Current Zoning: UR-C(CD) (urban residential – commercial, conditional)
Proposed Zoning: UR-C(CD) SPA (urban residential – commercial, conditional, site plan amendment)

Approximately 1.08 acres located on the west side of Providence Road, north of Ardsley Road, and south of Moravian Lane.

The petition proposes a site plan amendment to a previously approved petition, 2011-008, to allow for the site to be redeveloped with nonresidential uses.

**RZ-1.0**

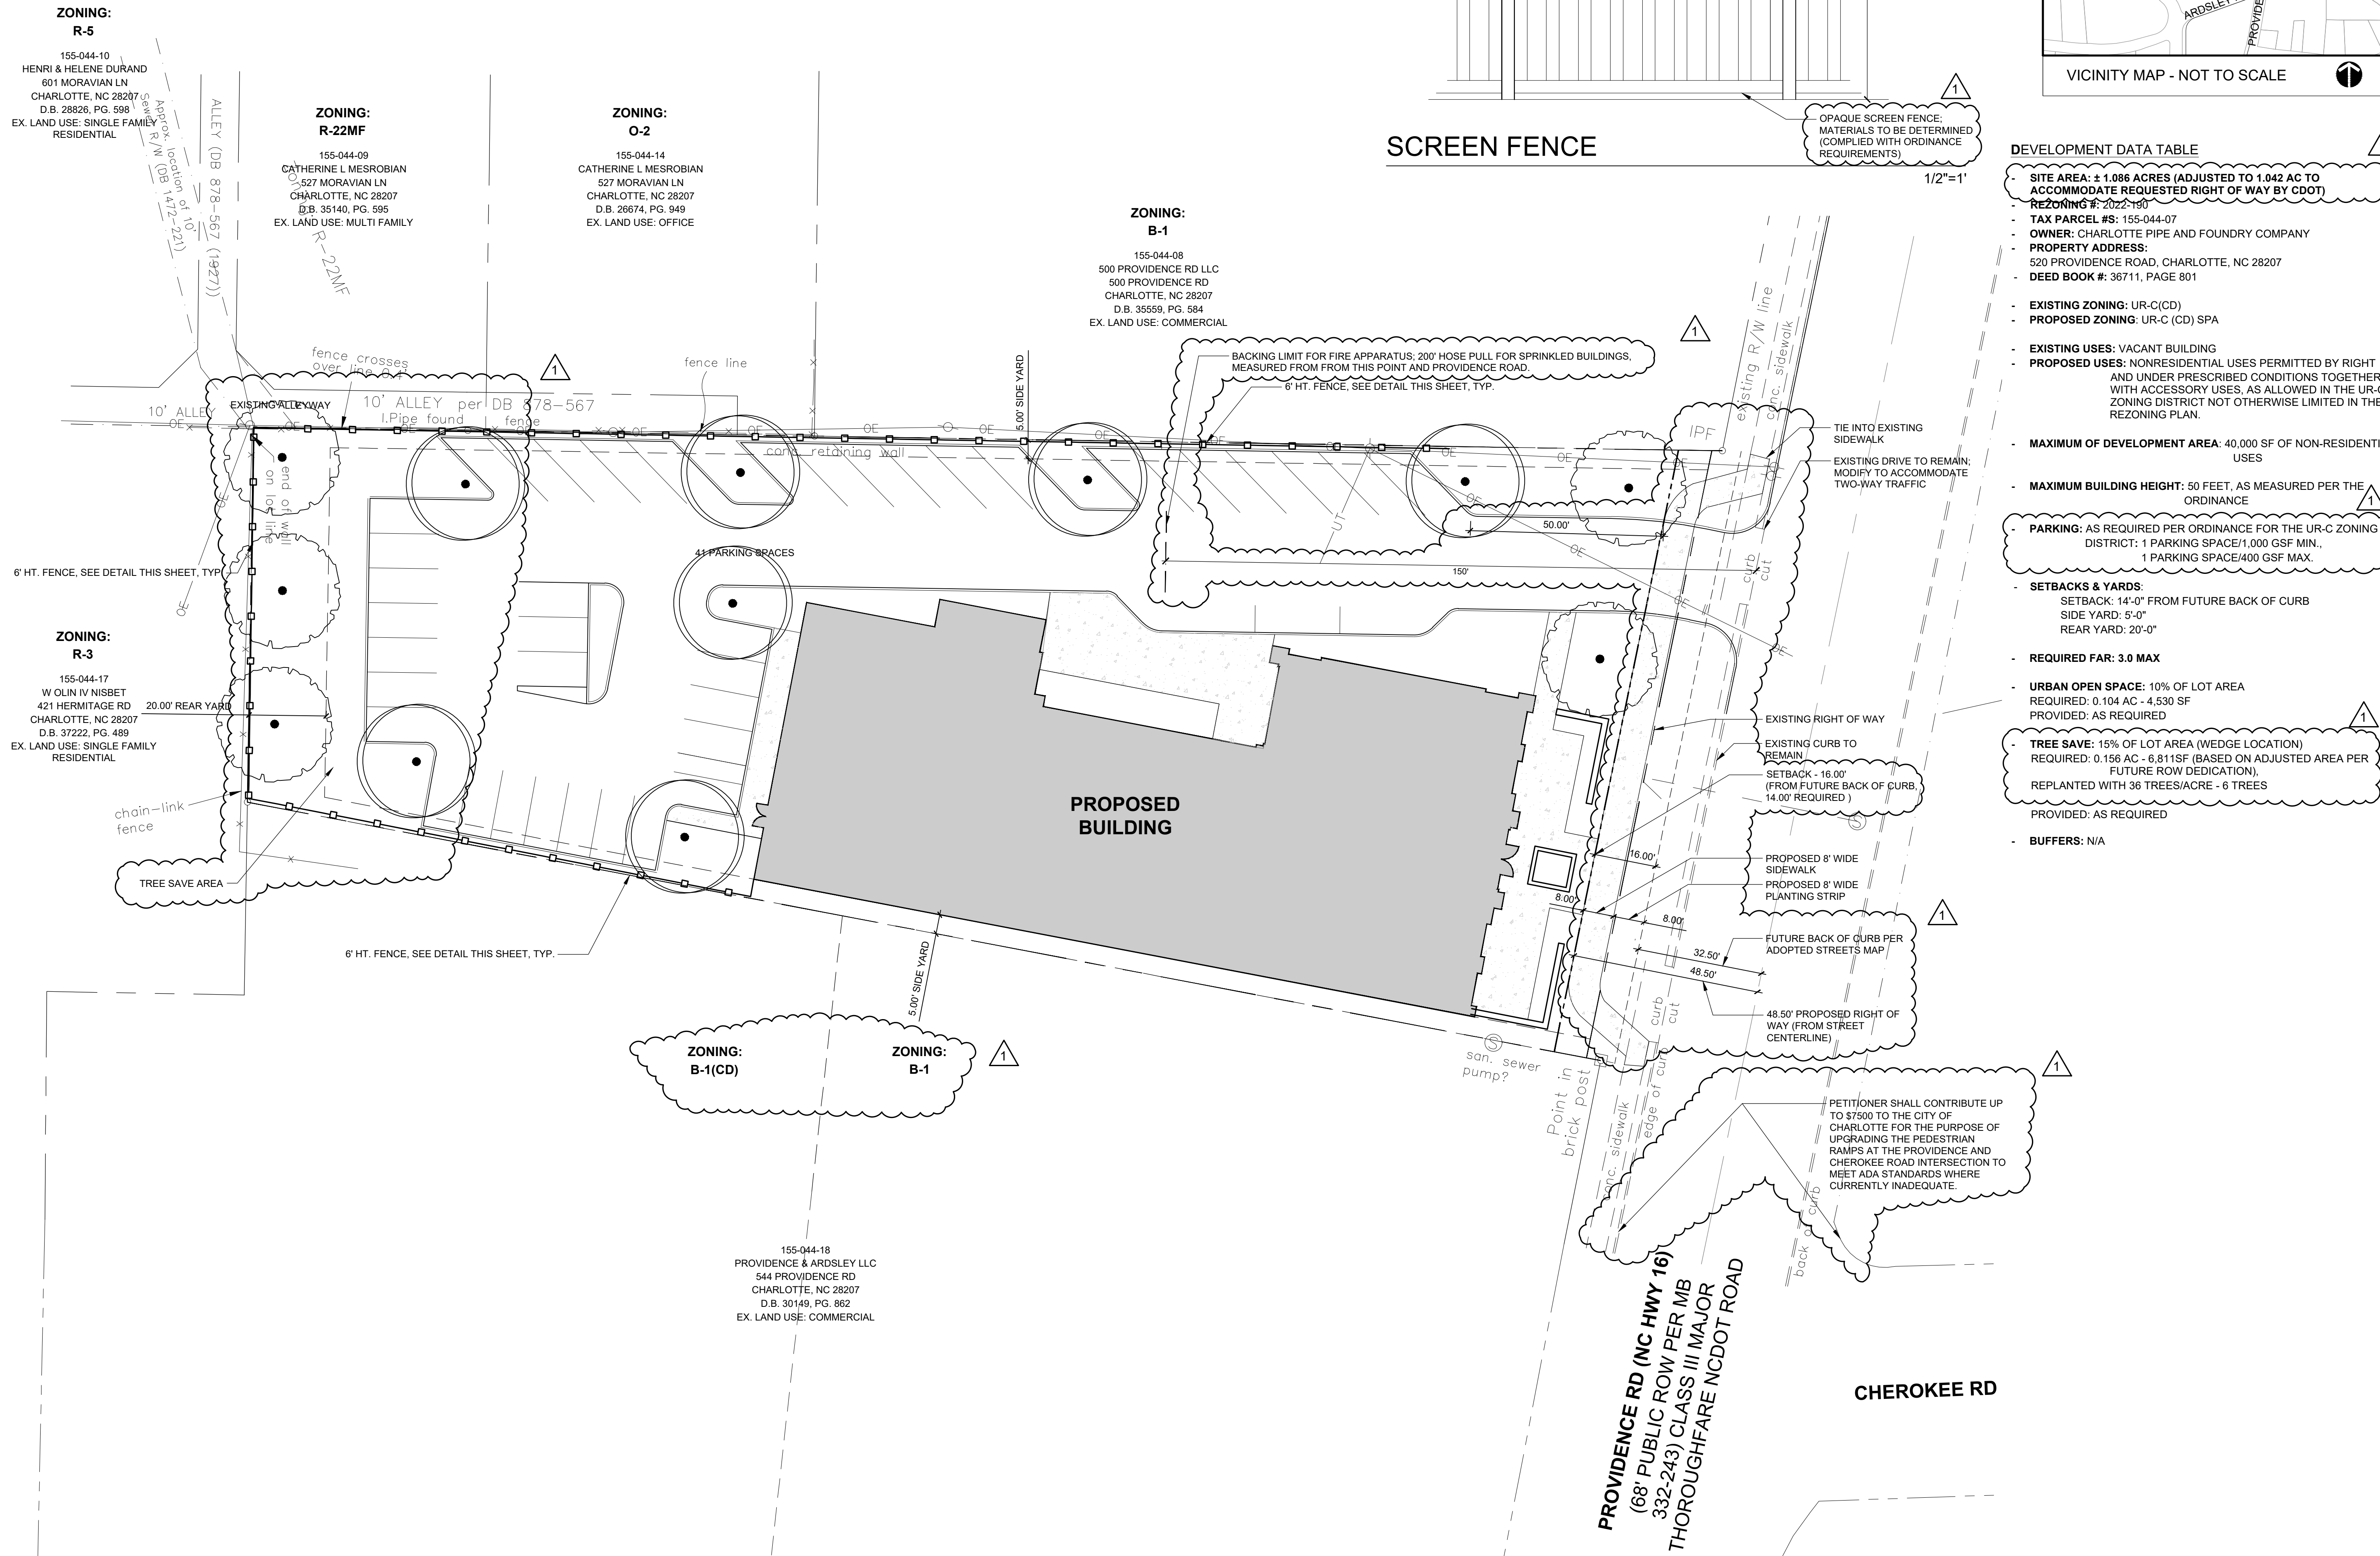
- ~~2. Revise the parking spaces on the northern and southern boundaries so that they do not extend into the side yards.~~ **Addressed**

- ~~3. The site plan shows a fence along a portion of the southern boundary, but the conditional notes only mention fencing on northern and southern boundaries. Clarify fencing commitments and update the notes as needed.~~ **Addressed**
